PRE-HEARING STAFF ANALYSIS

Rezoning Petition No. 2008 - 083

Request: R-4, single-family residential to INST(CD), institutional conditional district

EXISTING SITE PLAN

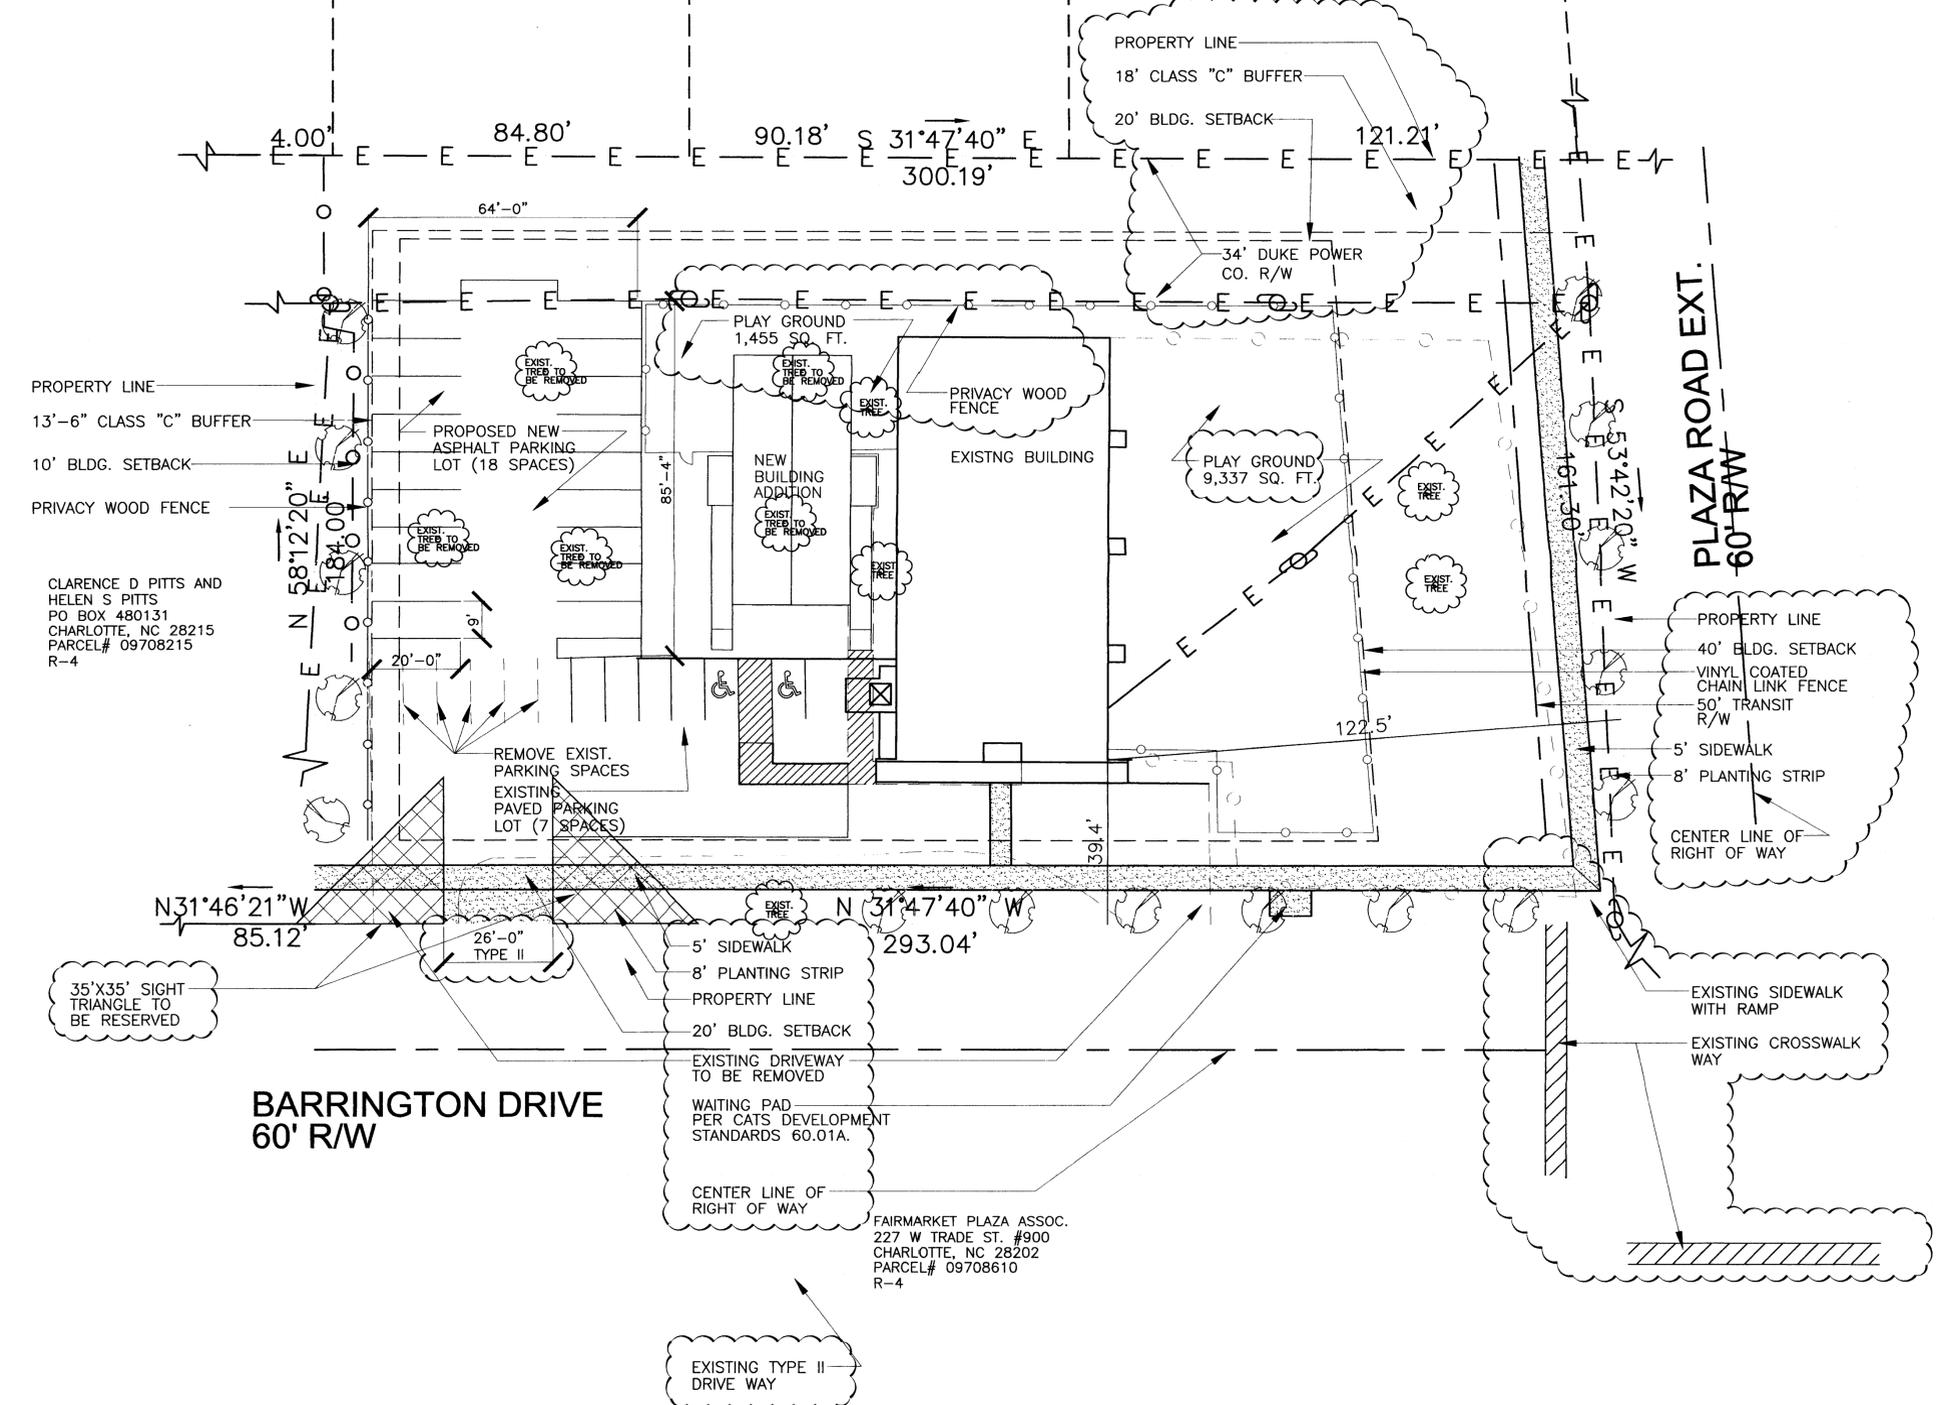
Traffic Impact / CDOT Comments. CDOT estimates that trips generated from the site would increase from the existing 400 to approximately 600. CDOT states that the existing driveways are in disrepair and should be replaced. The driveway closest to the northern property line should be moved to a location that aligns with the new parking lot aisle and be 26 feet in width.

CATS. CATS requests a concrete waiting pad on Barrington Drive.

- An alternative buffer should be shown for the area beneath the utility right-of-way.
- Maneuvering space within the side yard abutting Barrington Drive should be removed.
- Correctly label 20' rear yard that abuts Parcel #09708215.
- Clearly show rezoning boundary line, property line and utility right-of-ways.
- Correctly label sidewalks as 6'.
- Correctly show property line and building setback callout arrows along the Barrington Drive side of site.
- Use correct symbol for proposed wood fence.
- Remove Note number 1 related to storm water.
- Remove General Note numbers 13, 14 and 15.
- Include a note on the site plan that the petitioner will comply with the Charlotte City Council approved and adopted Post Construction Controls Ordinance.
